# Comments for Planning Application 24/00110/FULH

Application Number: 24/00110/FULH

Address: 37 Holywell Road Watford WD18 0HT

Proposal: Erection of ground floor single storey rear extension, first floor side extension and garage conversion into habitable space

Dwg no:	Revision.	Date:
0176-PR-10	D1	25.11.2023

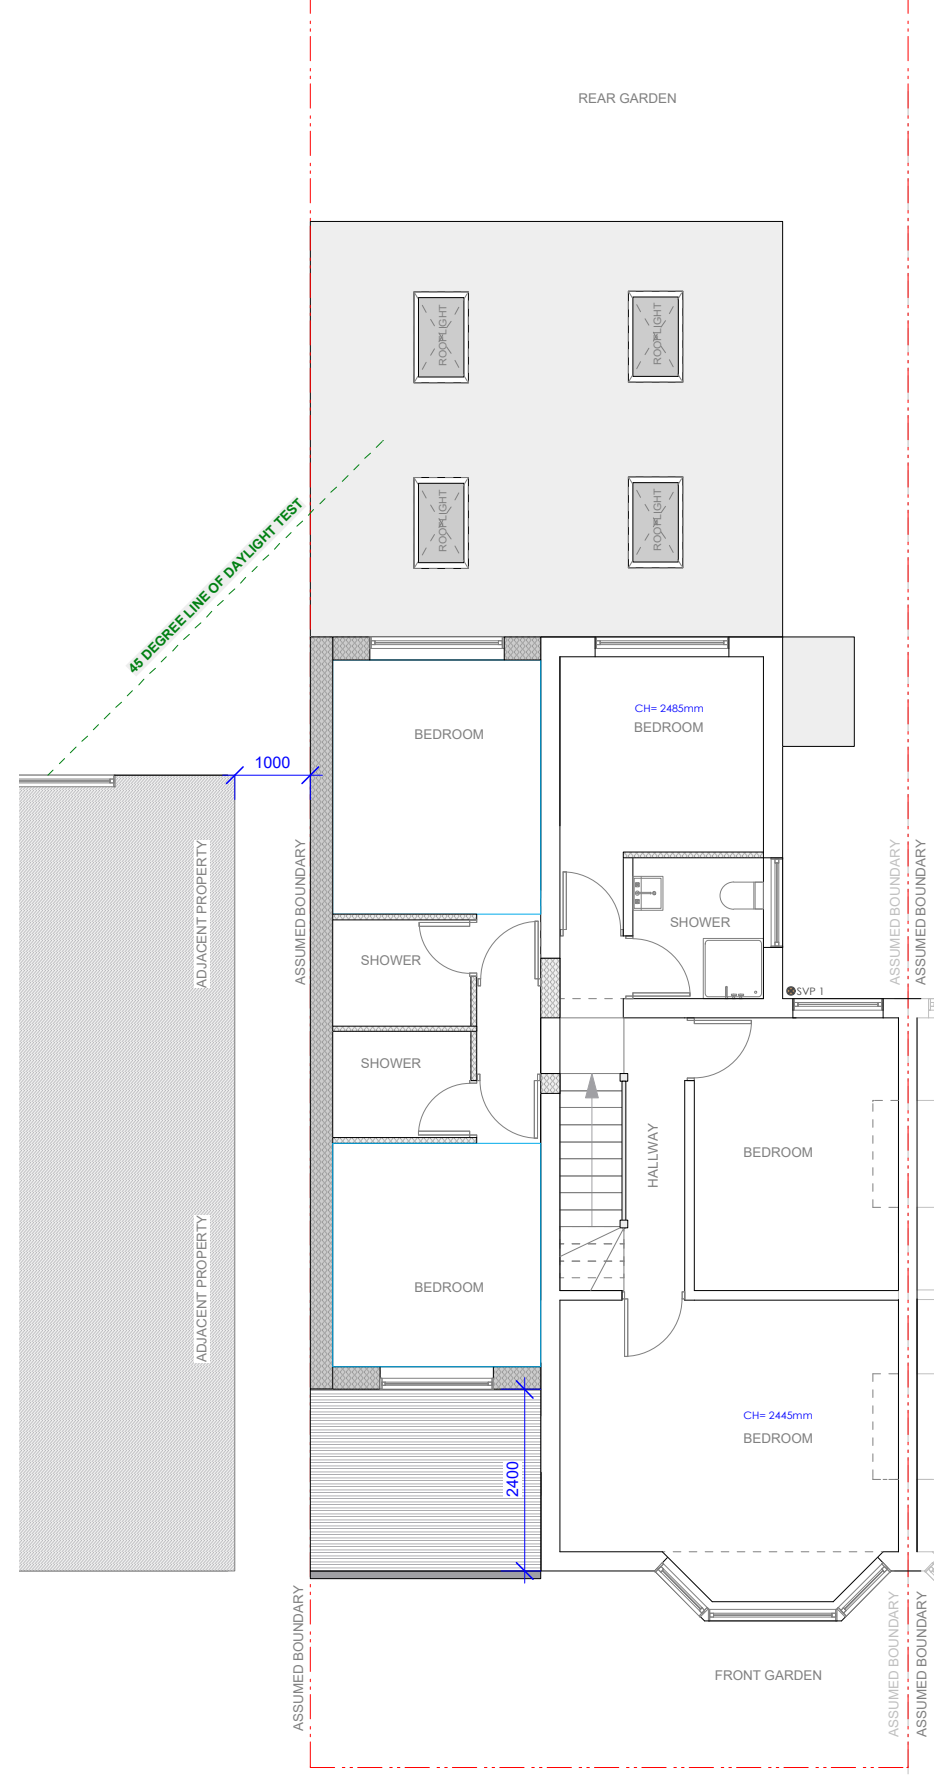
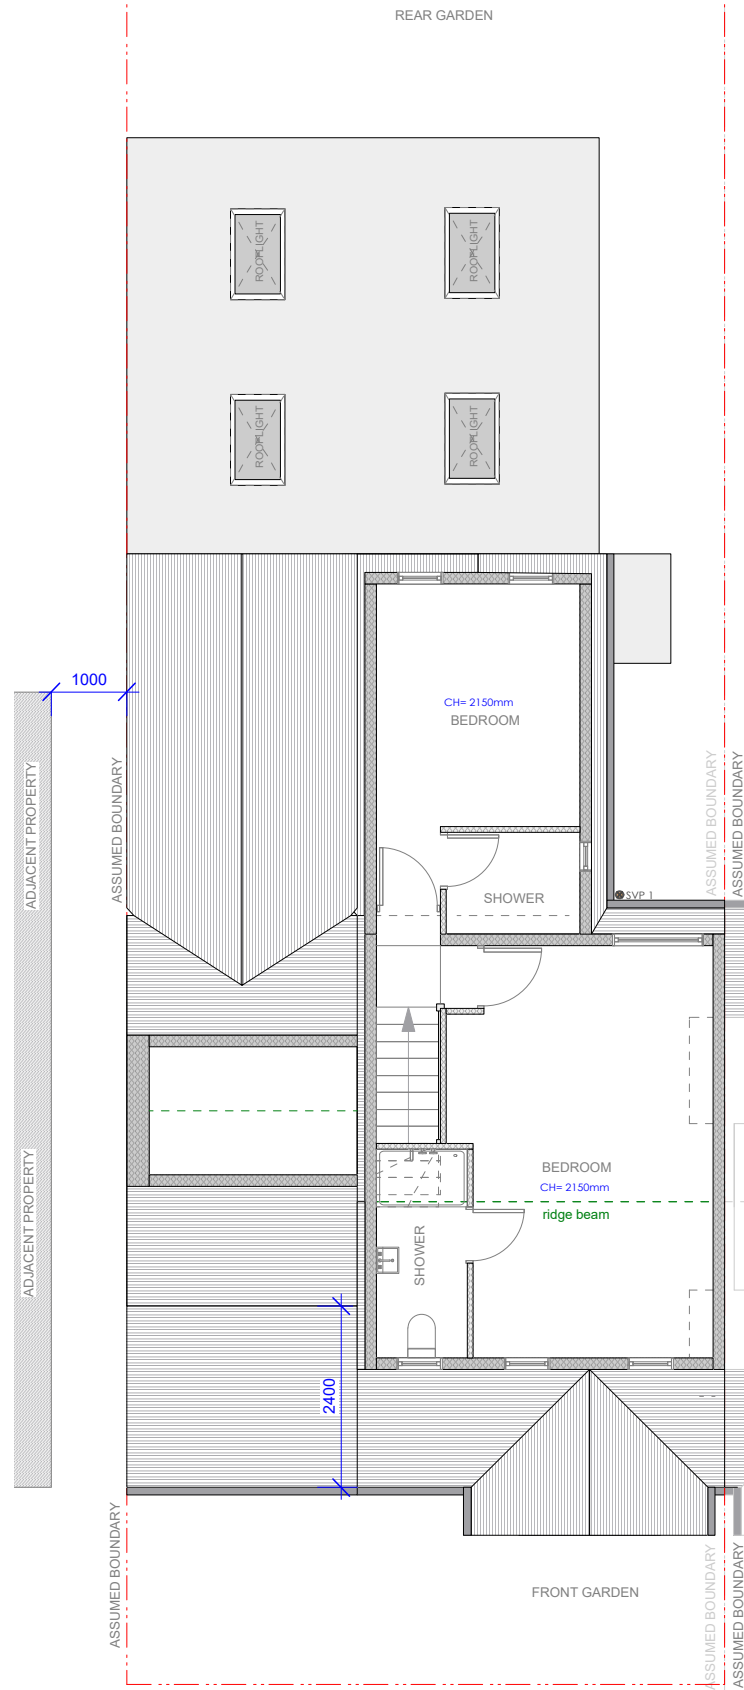
The proposed single story extension is grossly over-sized and going far too deep into the rear garden. The left flank wall is entirely on our joint boundary and it is indicated to be 3m in height for the rear extension. The 45 degree line of vision from the down stairs patio door and upstairs bedroom window clearly shows that the extension is too far deep into the applicant's rear garden and will affect enjoyment of my property and will have negative material financial impact on the value of the property. The depth of the proposed single storey extension will have a daunting and entirely undesirable effect on the garden affecting my enjoyment of it. The garden will be a part prison wall 3m (10feet) high. Bird's eye view examination (using BING UK MAPS) of the applicant's entire side of the street shows no precedent approval of such a large rear garden extension infringement of planning rule of visibility. For all the reasons just stated, the planning application should be refused. Any planning application granted for the rear extension should have a condition to only allow non-opening flush sky-lights to the roof in order to restrict visibility intrusion. Naturally, conditions related to working hours should be stipulated to minimize impact on the residents at No 31.
